Andy Sime
London Pilots Council

Thanet Windfarm Extension Deadline 4a Submission

9th April 2019

Drg No	Fig 1.1_TEOW_RLB			Figure 1.1
Rev	0.1	Date	25/05/2018	
By	DP	Layout	N/A

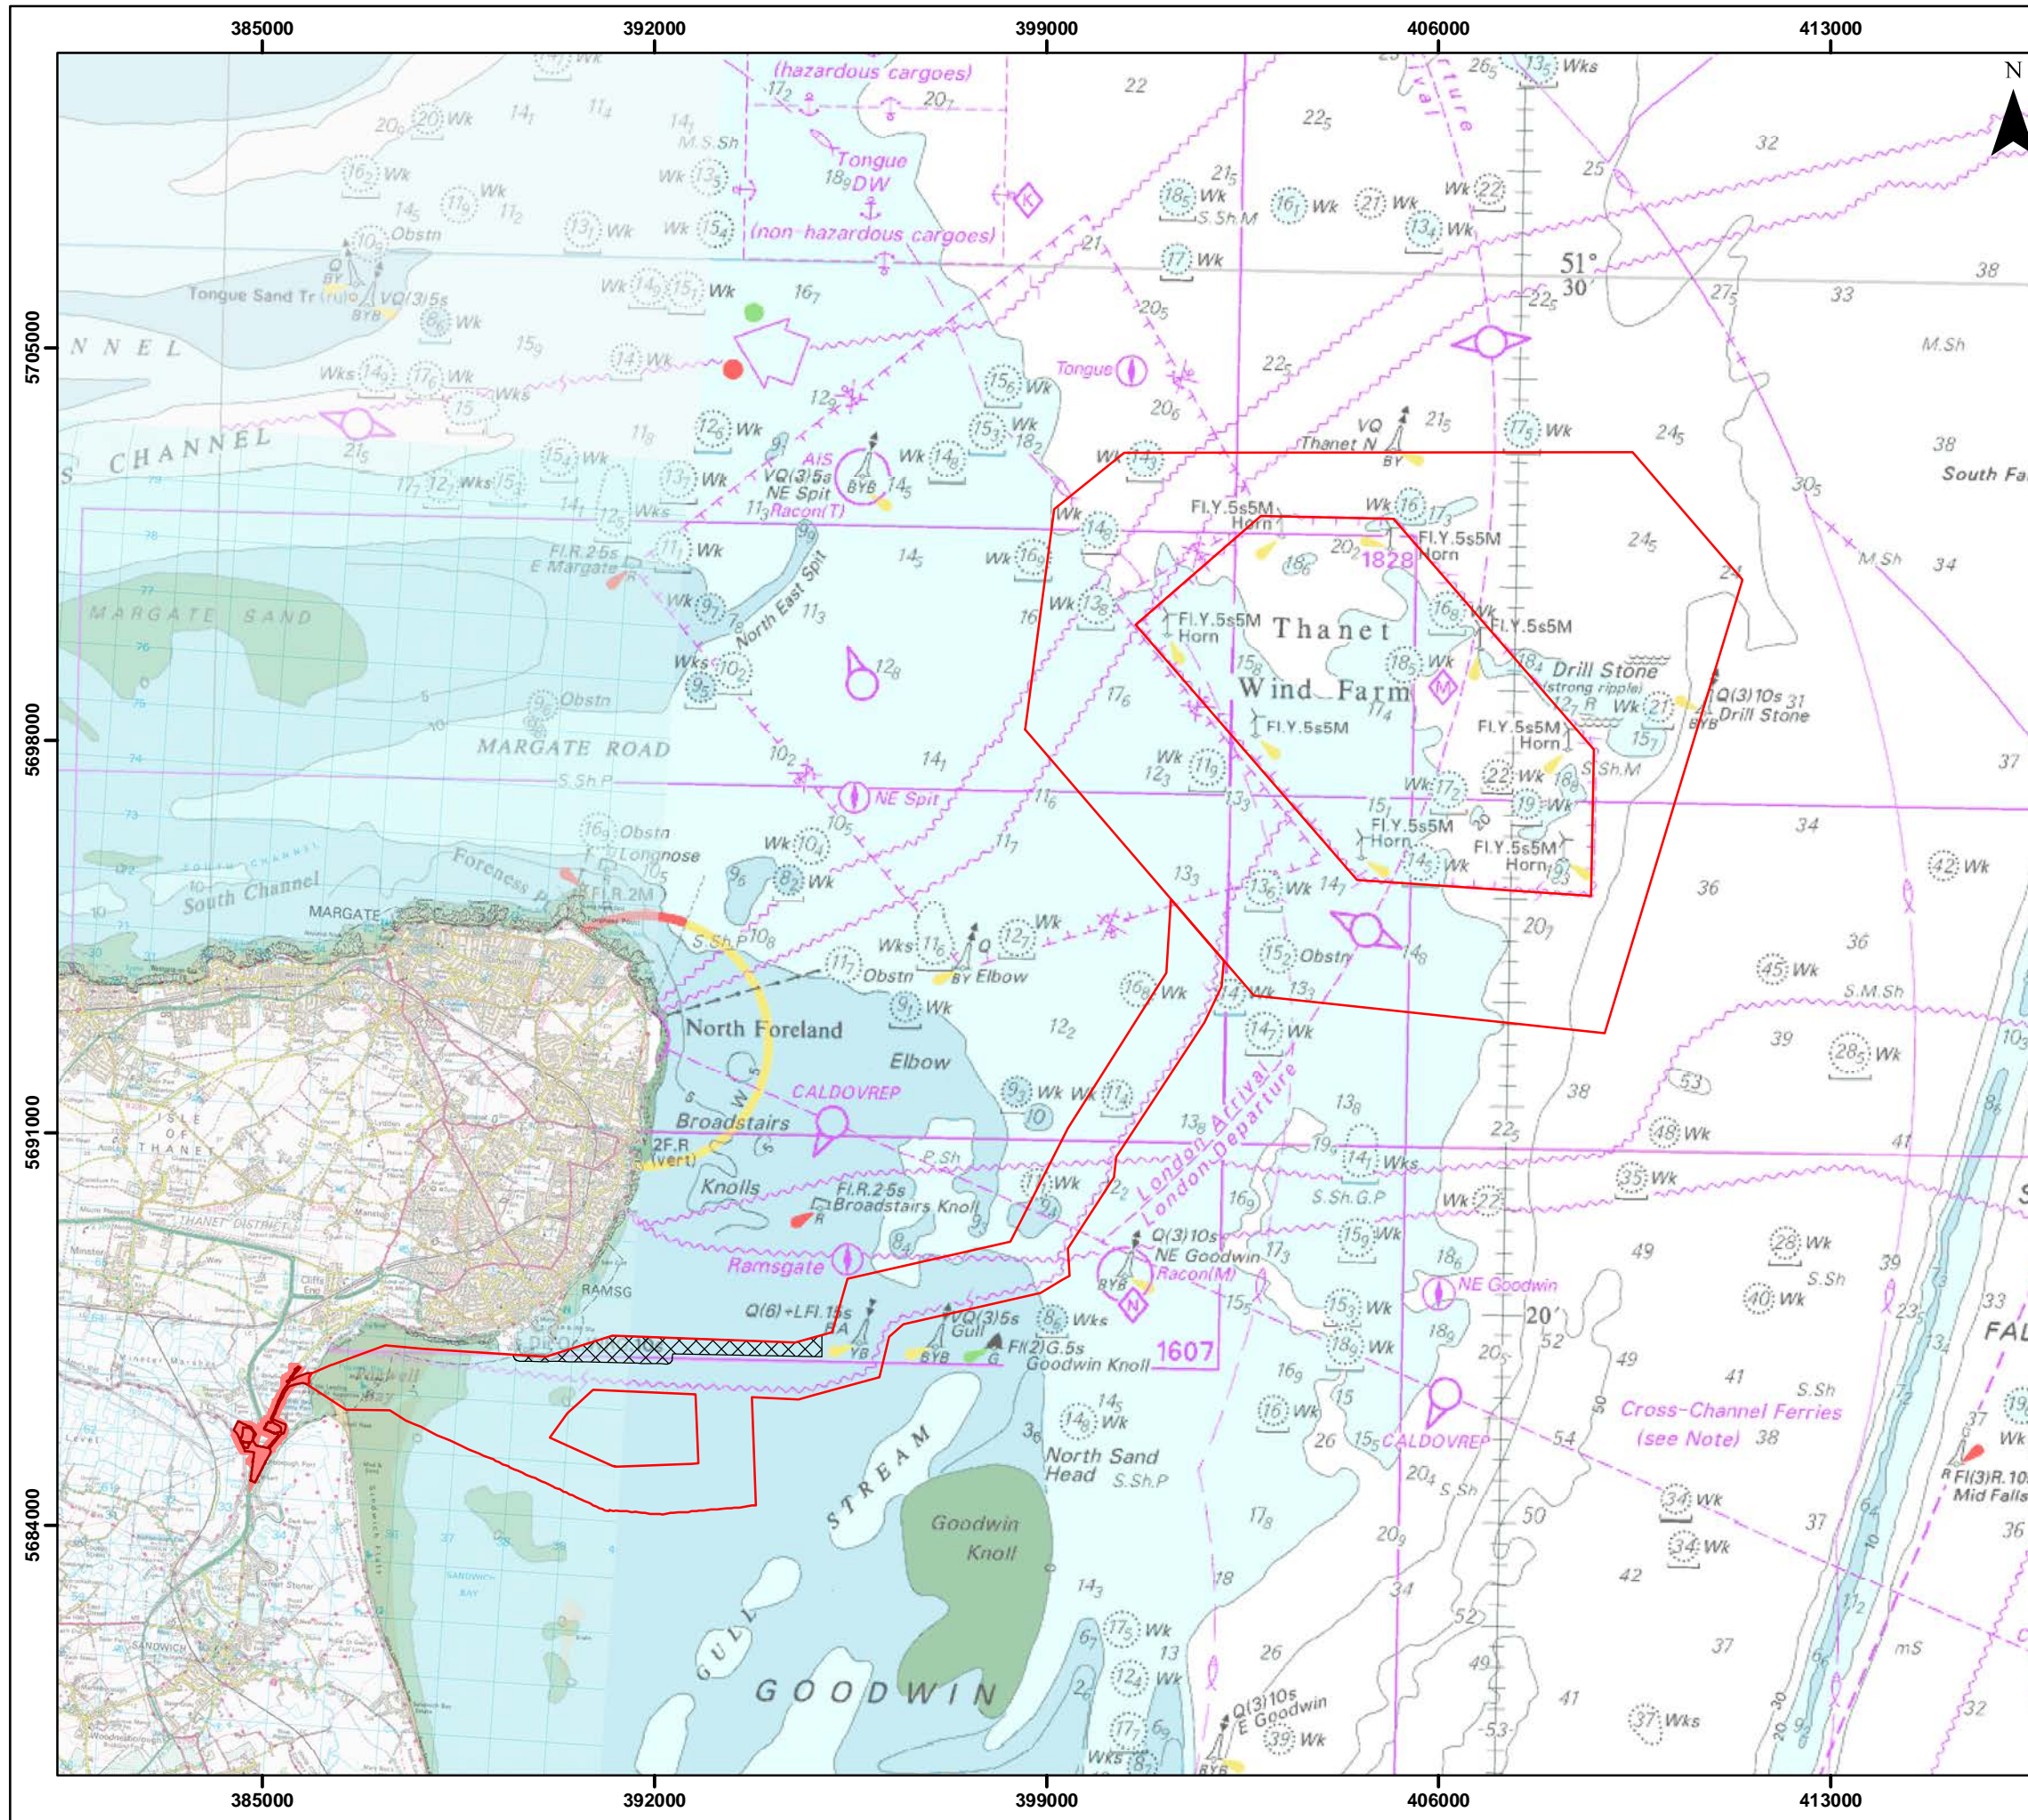
- 1.1. Further to the workshop and IP meetings organised by the Applicants the LPC wholly reject the revised red boundary proposed as a result of the workshops on the grounds of Navigation Safety in and around the NESP area.

- 1.4. With the benefit of this experience the LPC are adamant that the proposed 0.5 mile SEZ of the revised red line boundary leaves insufficient sea room and safety margin for manoeuvring large vessels at the NESP during Pilot operations. Furthermore the loss of sea room and proposed 0.5 mile SEZ significantly increase the risk of close quarters situations between vessels, allows negligible room for emergency contingencies and represents an increased risk to the personal safety of the Pilots and Mariners alike.

3.4. Figure 3 clearly shows that the proposed SEZ to the North of the proposed red line boundary pushes the Thanet North Buoy further north into the East/West sea lane. The sea room to the West of the Windfarm has been restricted and the line of sight required by the vessel forces the vessel to make a sharper turn down to the

6.2. The Applicants revised red line boundary actually increases the need for further sea room due to the tight angles created when vessels dip down to board and land Pilots. The LPC has provided actual vessel data showing turning circles and stopping distances to support this. It is without doubt that a 0.5 mile SEZ does not allow sufficient margin for speed and position adjustment when the vessel arrives at the NESP

- 1.6. In this submission the LPC offer a 'trade off' in SEZ. The inshore area to the SE of the current Pilot Diamond, at the Elbow Buoy, has fewer Pilot transfer operations than the area immediately at the Pilot Diamond. Many of the vessels transiting through this area at the Elbow Buoy are smaller Class 3 and Class 4 vessels and go on to transit over the NESP bank. These vessels have lesser manoeuvring and sea room requirements. In this area we would agree a 1.5 mile sea room with a 0.5 mile SEZ as shown on the applicants revised red line boundary plan. However, it is imperative that the 2 miles of sea room

plus 1 mile SEZ is maintained at the Pilot Diamond and to the North East of the diamond.

- Elbow Buoy total distance to be not less than 2 miles
- South of the NESP Pilot boarding diamond to be not less than 2.75 miles
- Pilot boarding diamond to be not less than 3 miles
- NESP Racon Buoy to be not less than 3 miles
